Application no: H16-0810-10

Description: Details of bricks and mortar, roof covering, external doors, construction details and colour scheme (Conditions 3, 4, 5, 6 and 7 of H16-0551-10)

Location: 2 Winsover Road
Spalding
Lincs
PE11 1EJ

ACKNOWLEDGEMENT OF AMENDMENT

Scale: 1:10 1:25	Drawing No: 1029-04-B
Date: SEPT '10	Drawn: J.C.

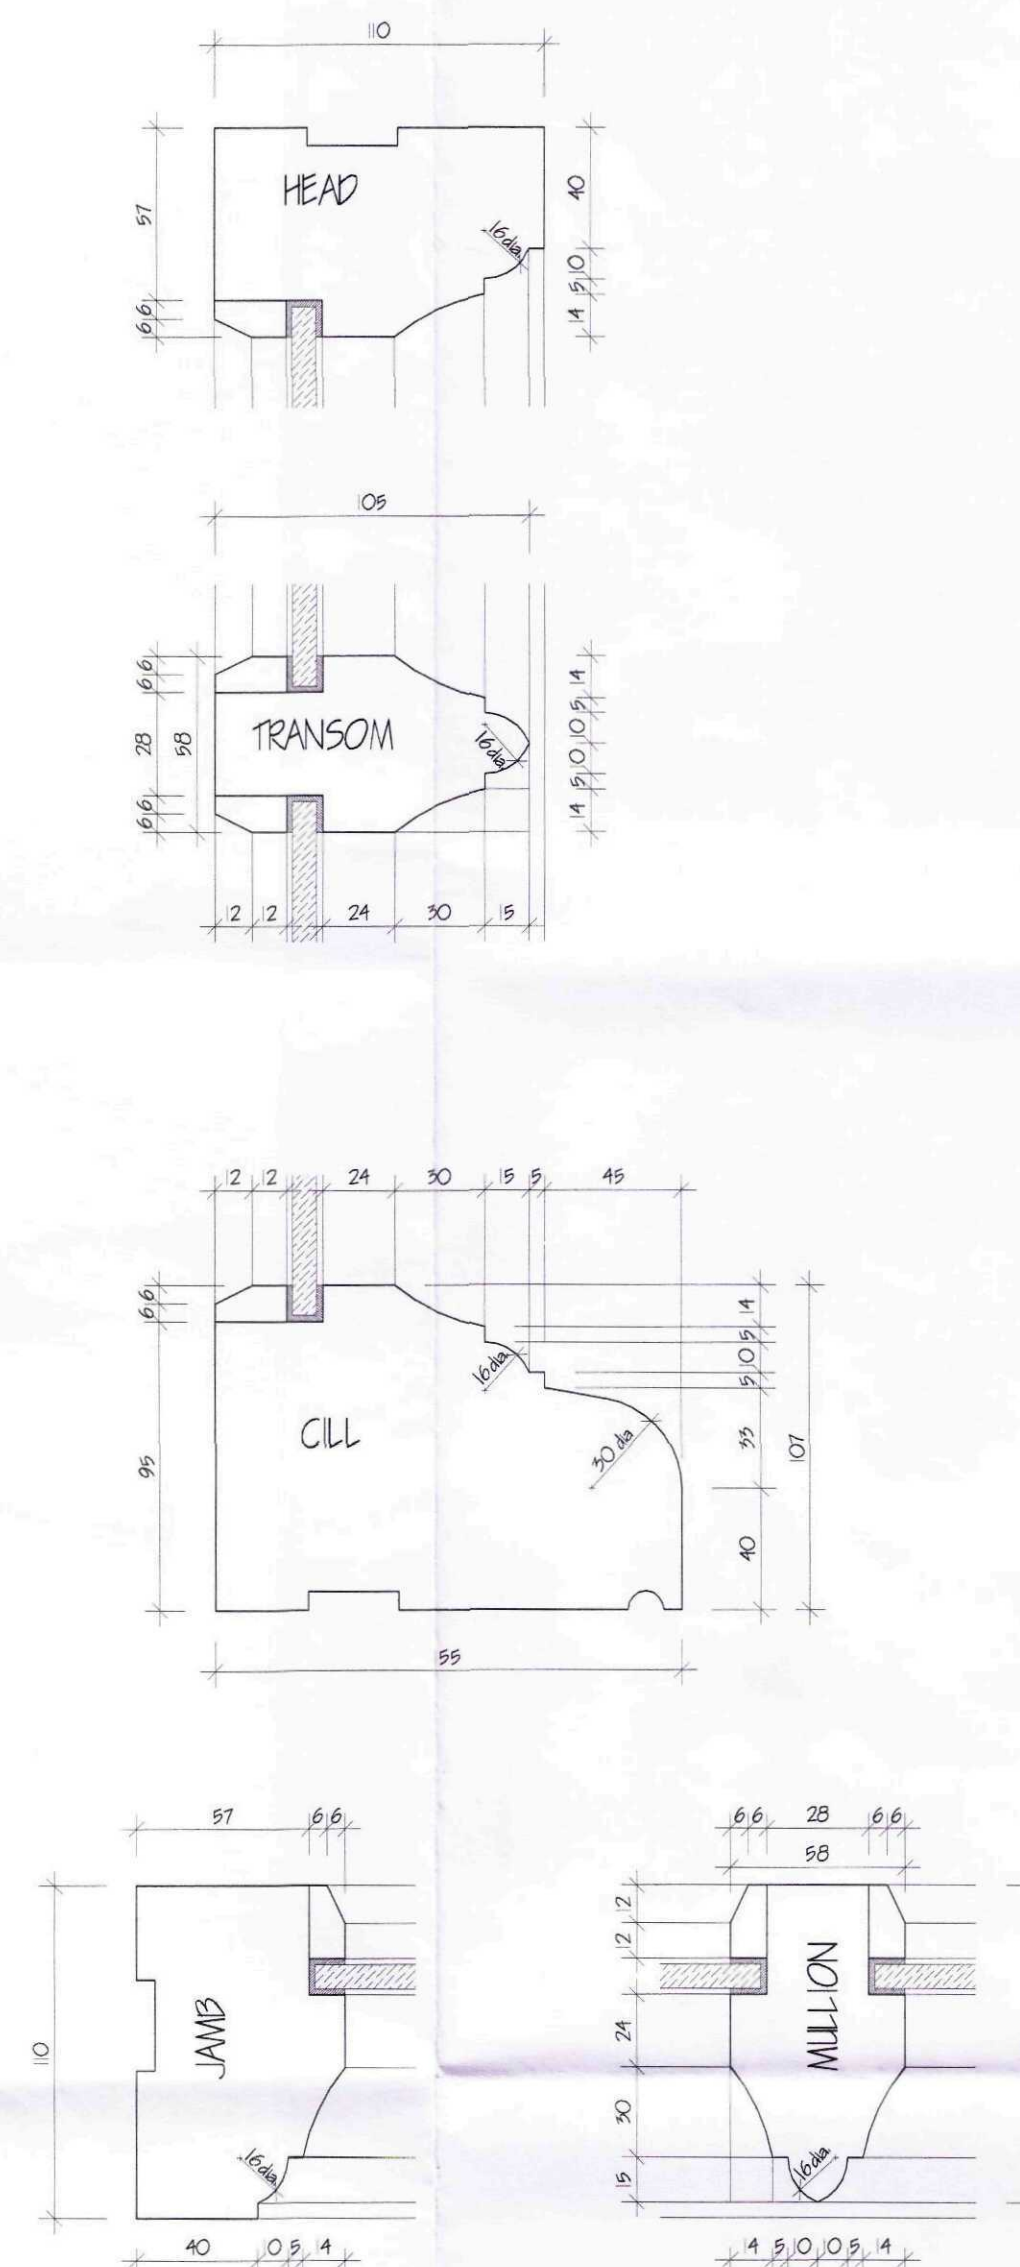
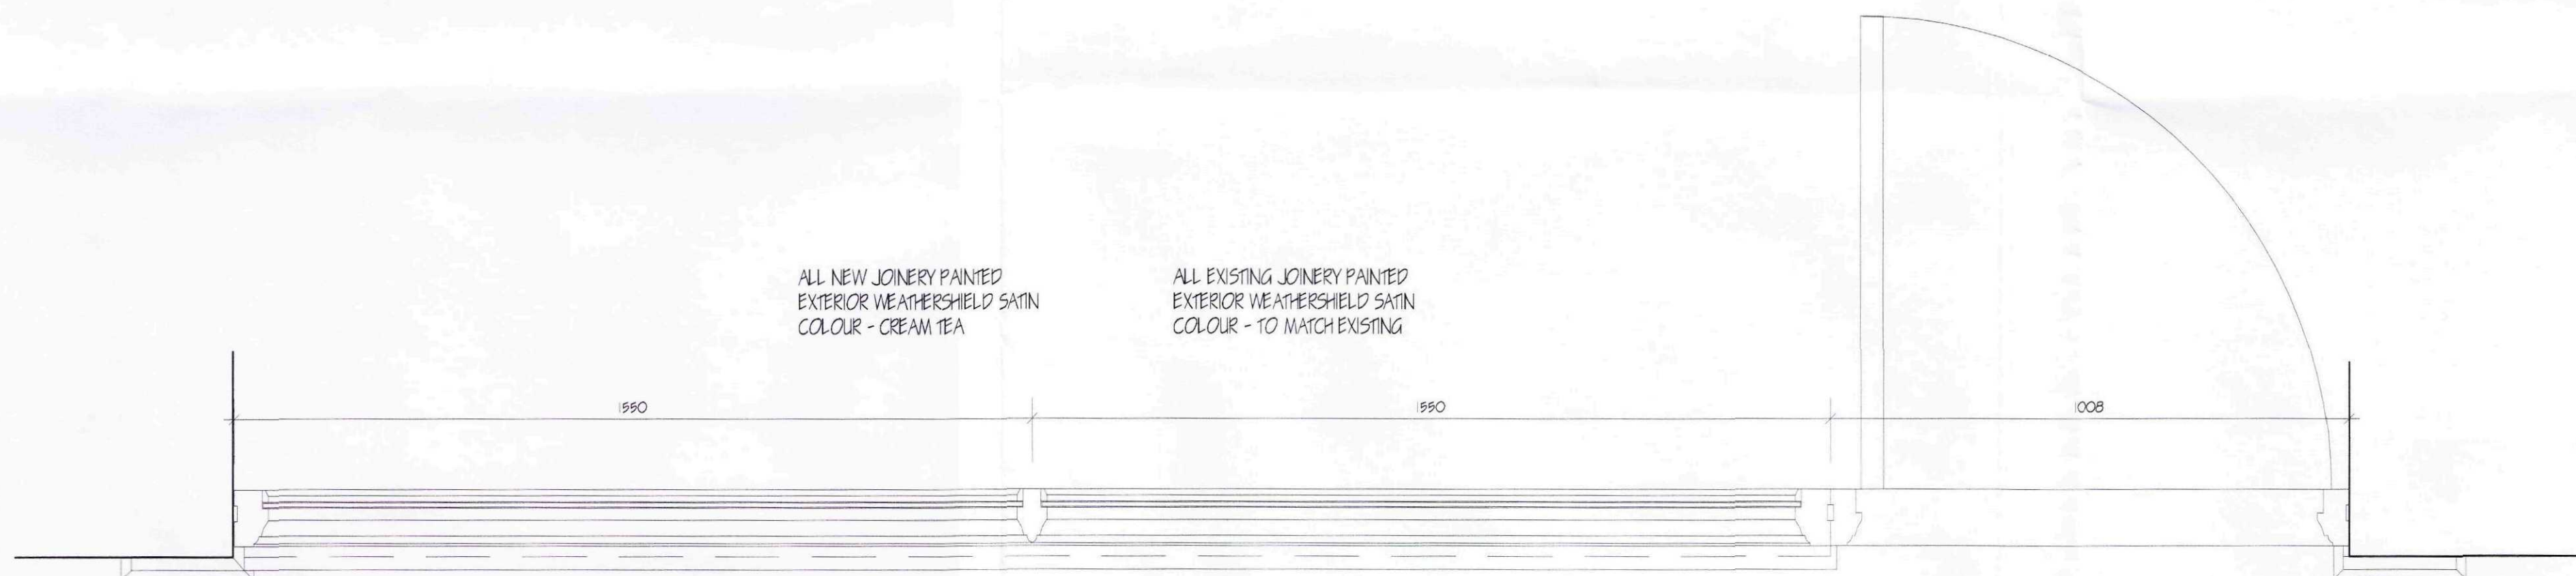
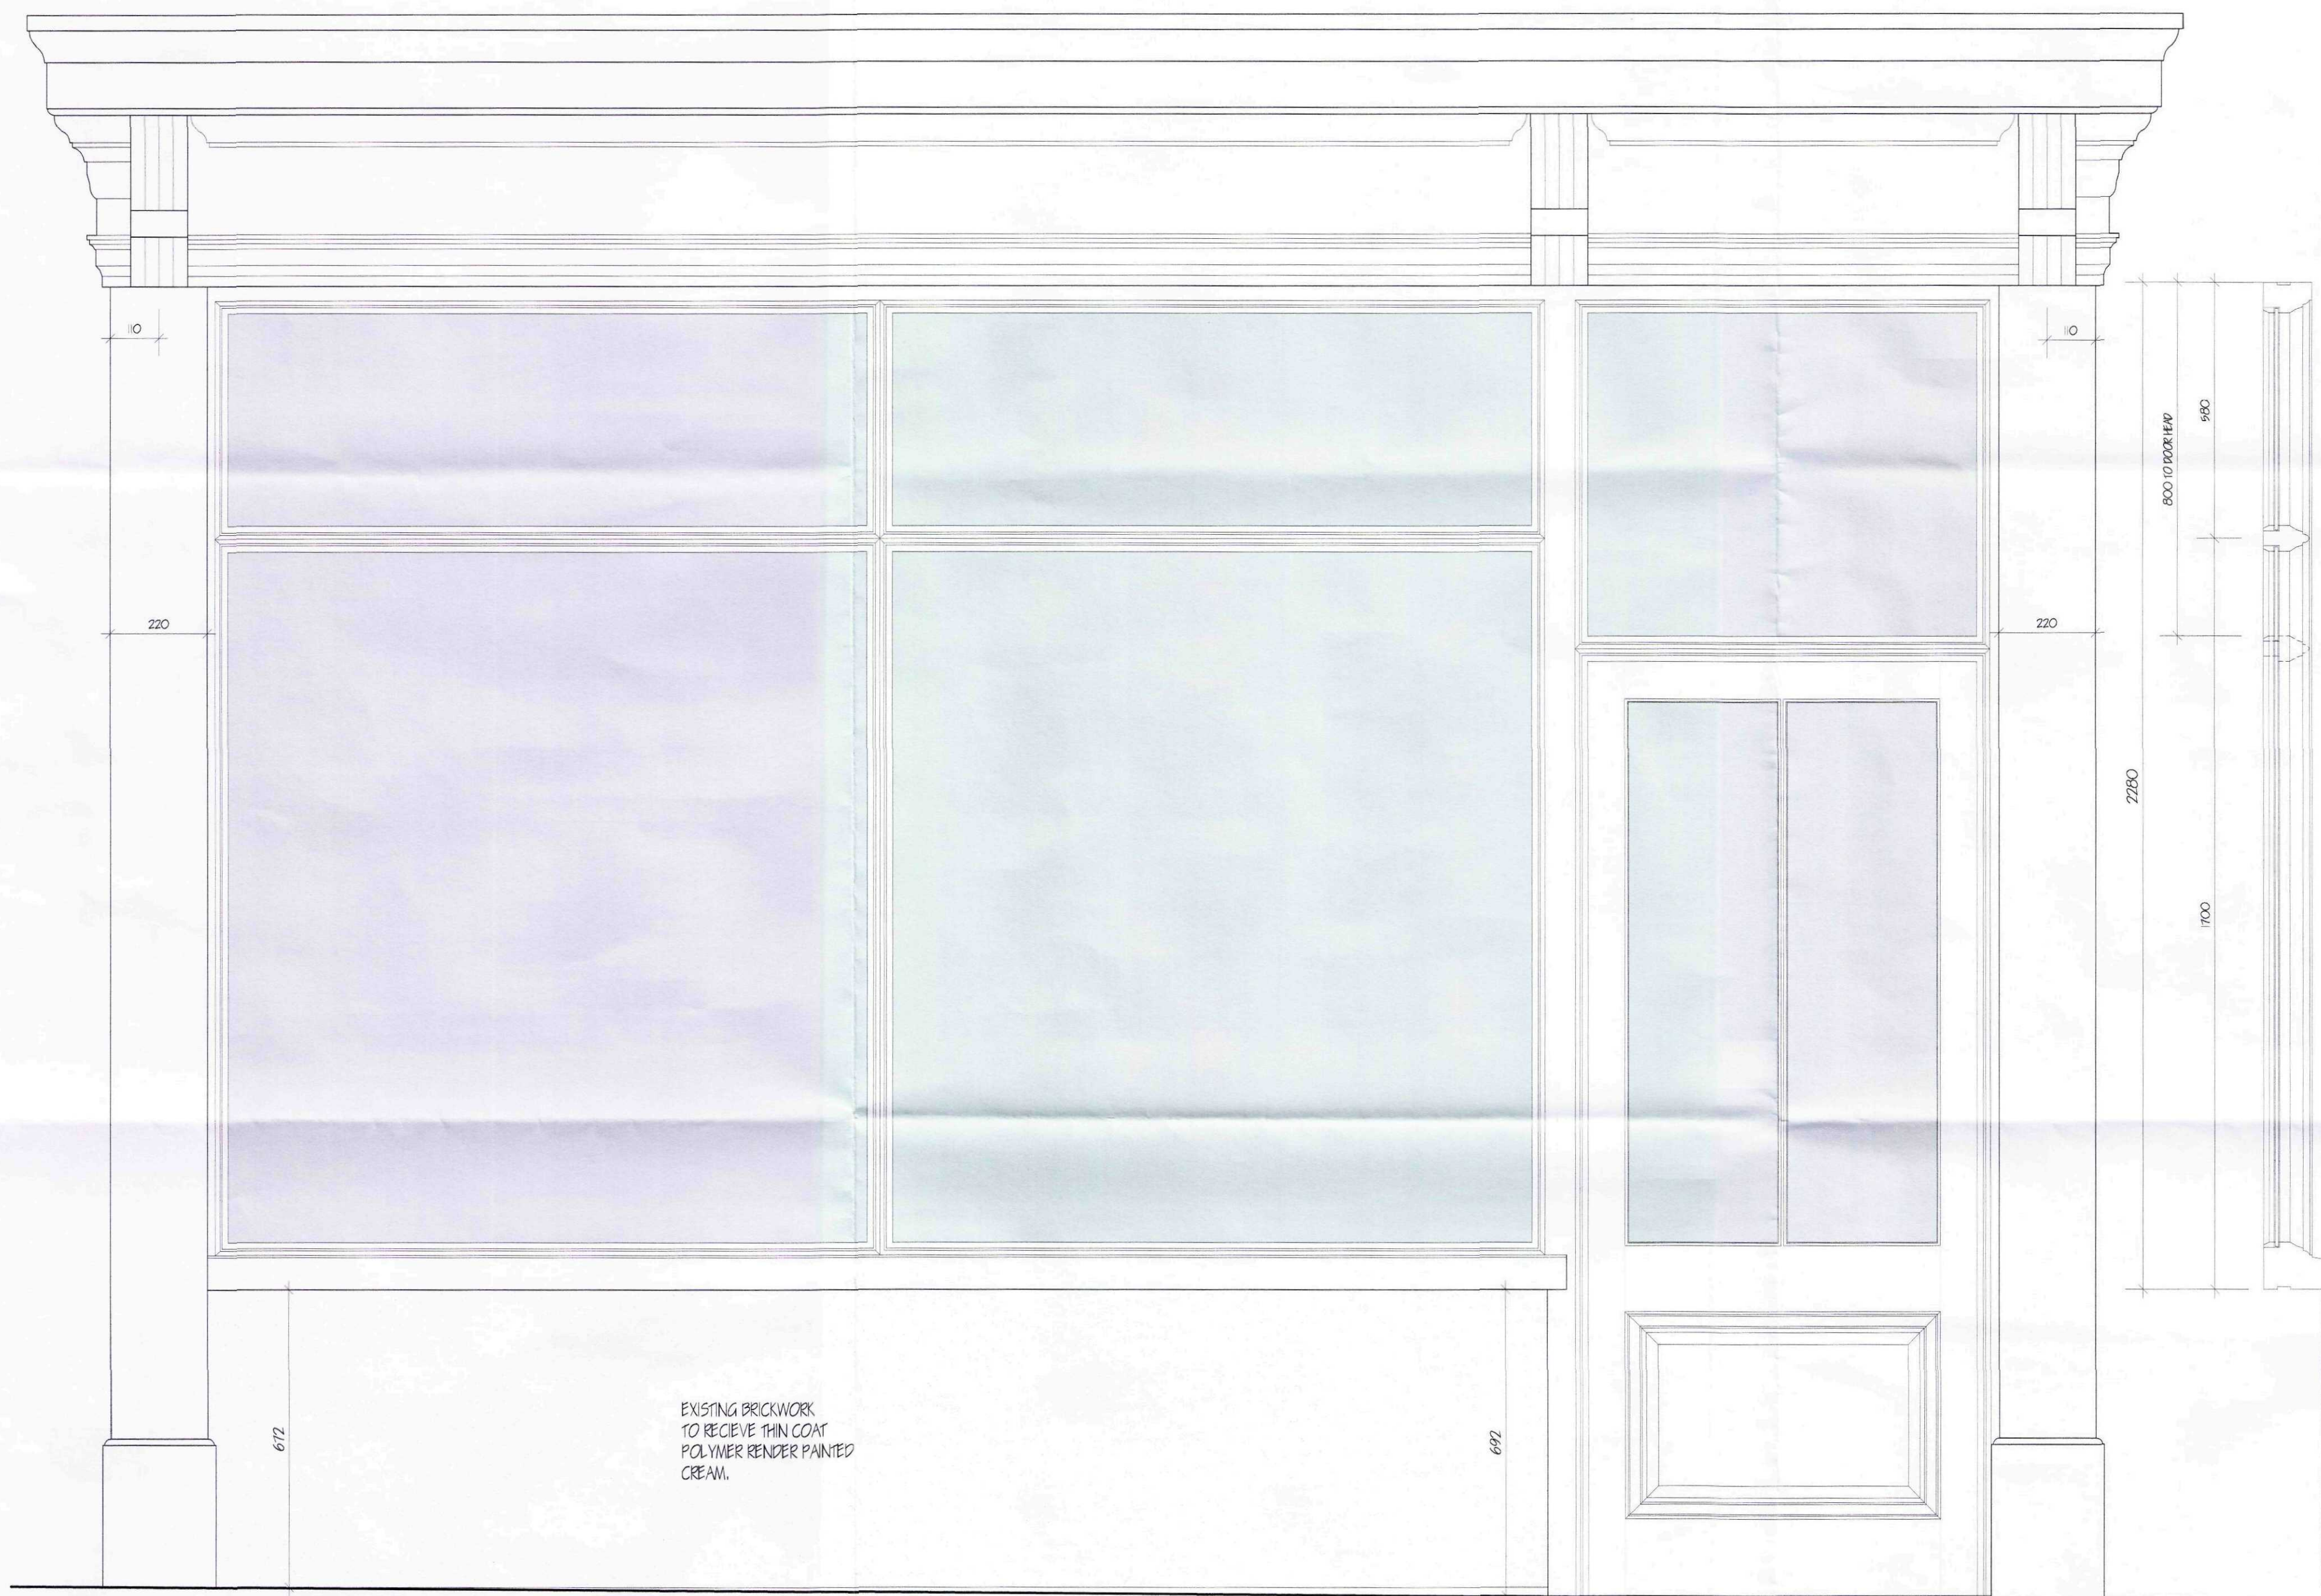
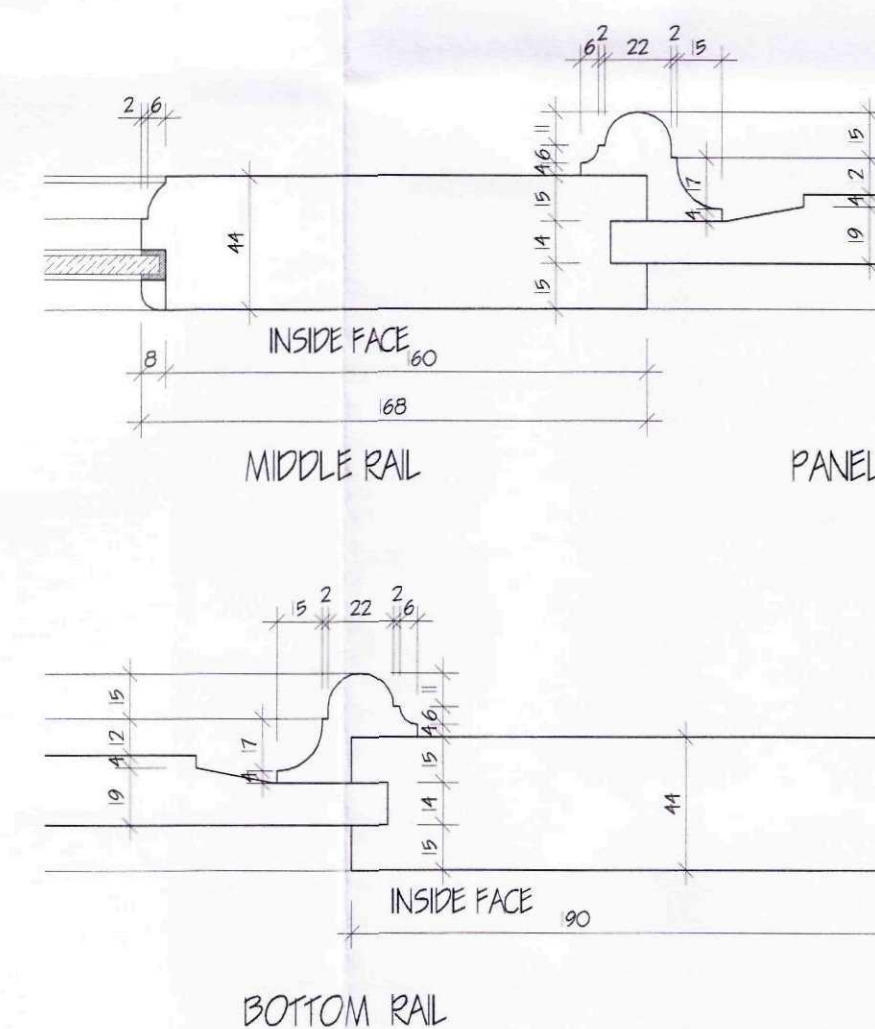
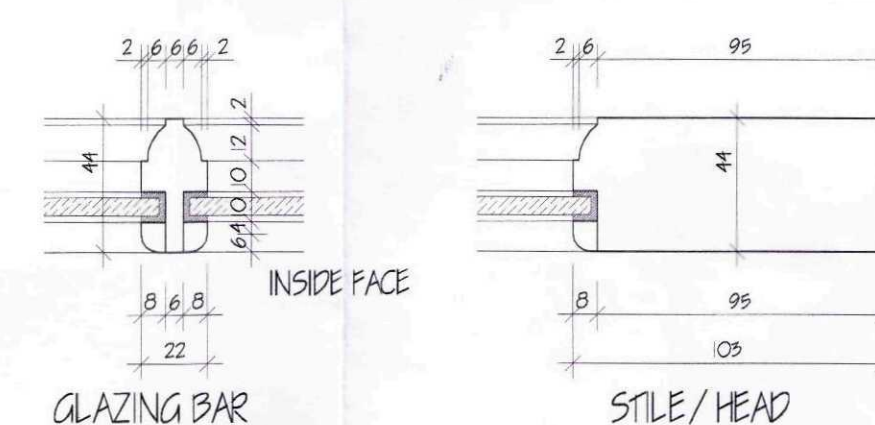
Amendment: Shop front details amended. Use of white cement in lieu of u.p.c for mortar (dwg. no. 1029-04-A)
